Council Office Extension  
Ref N6/2013/1938/MA

My objections to this planning application are :-

Title Proposed Materials

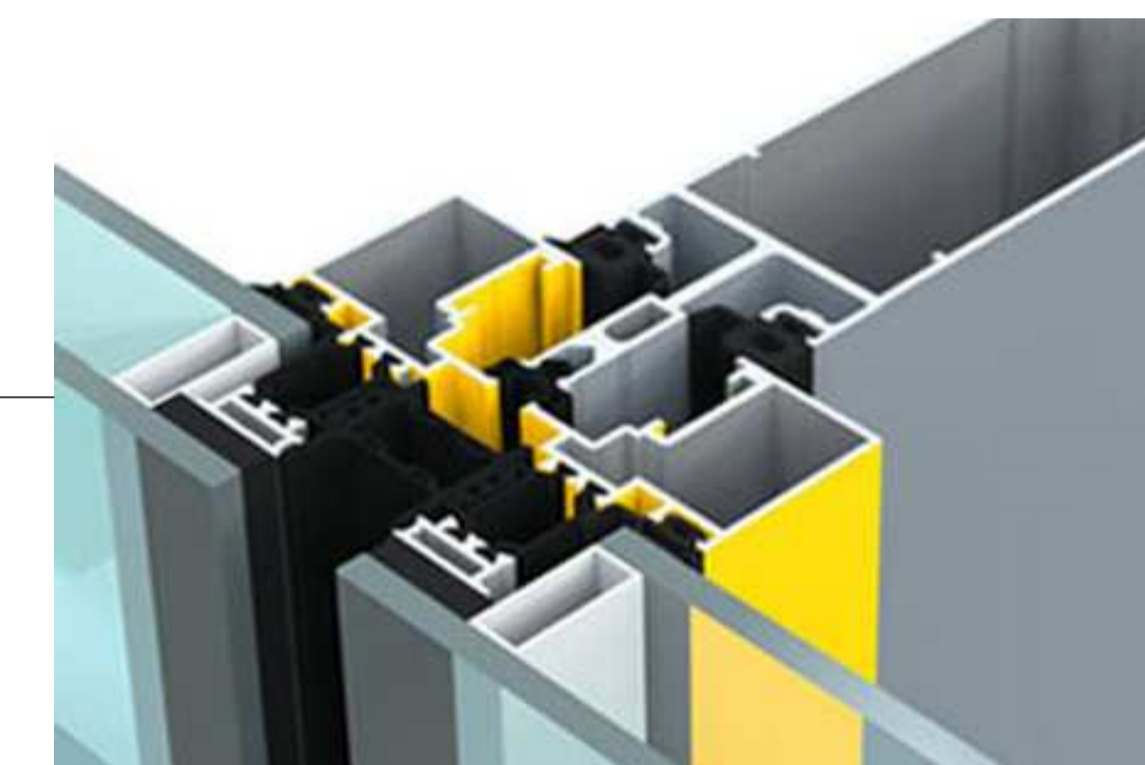
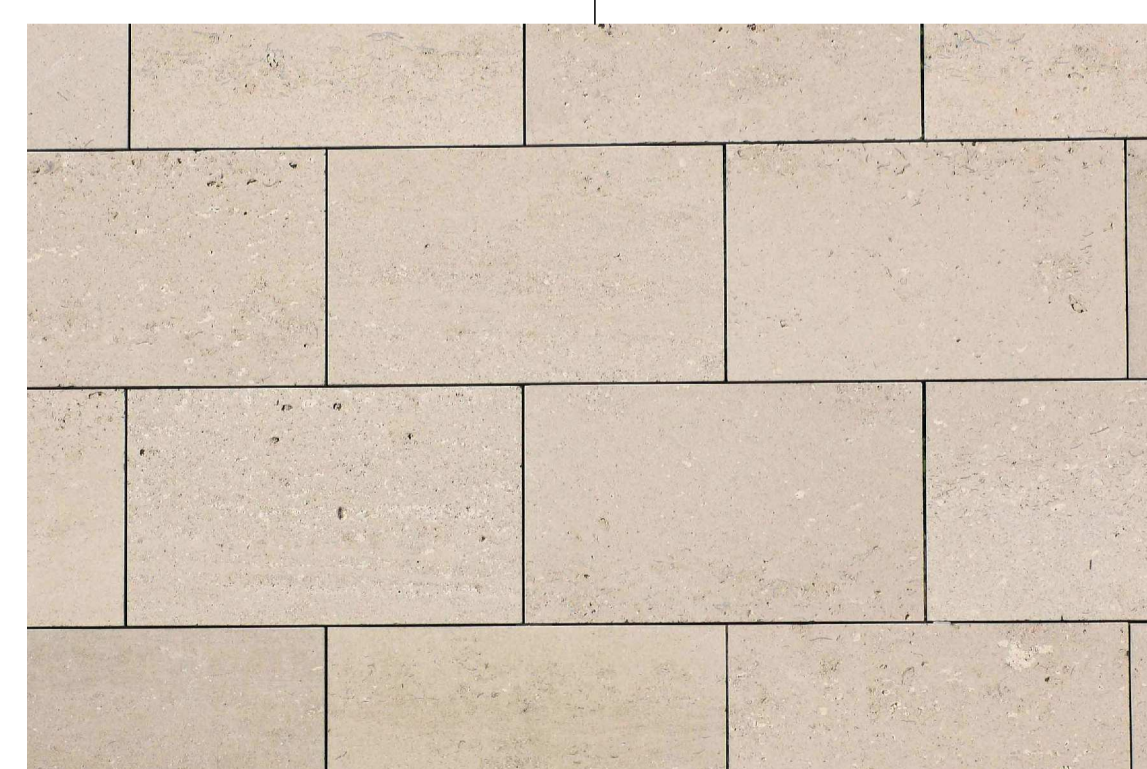
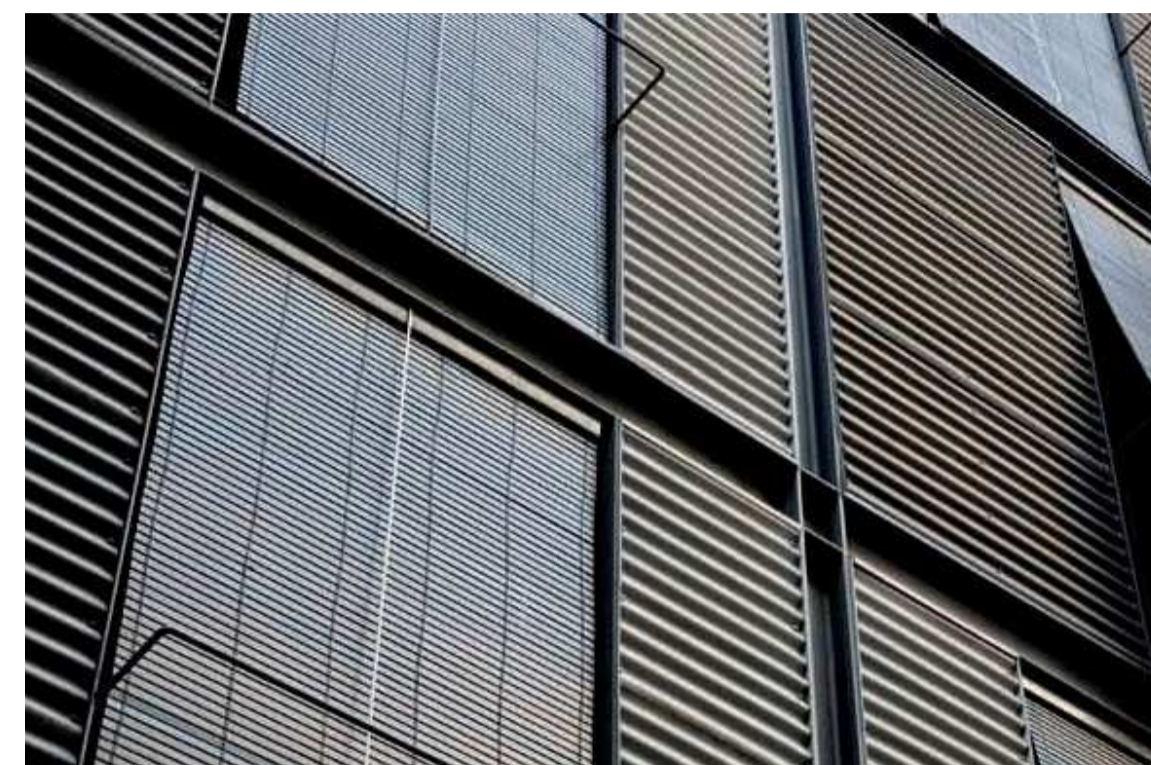
2. The exterior elevation of the proposed extension, which will require some demolition of the current SE and SW ends of the elevation, and not at the present approximate mid third building break lines, is not at all in keeping with the present brick elevations, each end of which is retained. Both remaining ends of the elevation are also altered by blocking up or inserting doorways and changed window widths and heights. The new "In your face" stone and glass mid-elevation is out of all proportion and does not in any way match up to or enhance the existing elevation.

3. The Planning Application does not appear to conform to the Councils own Planning Departments requirements for properties in the Conservation Area requiring planning permission. The proposals do not respect the materials or settings of the rest of the adjacent buildings.
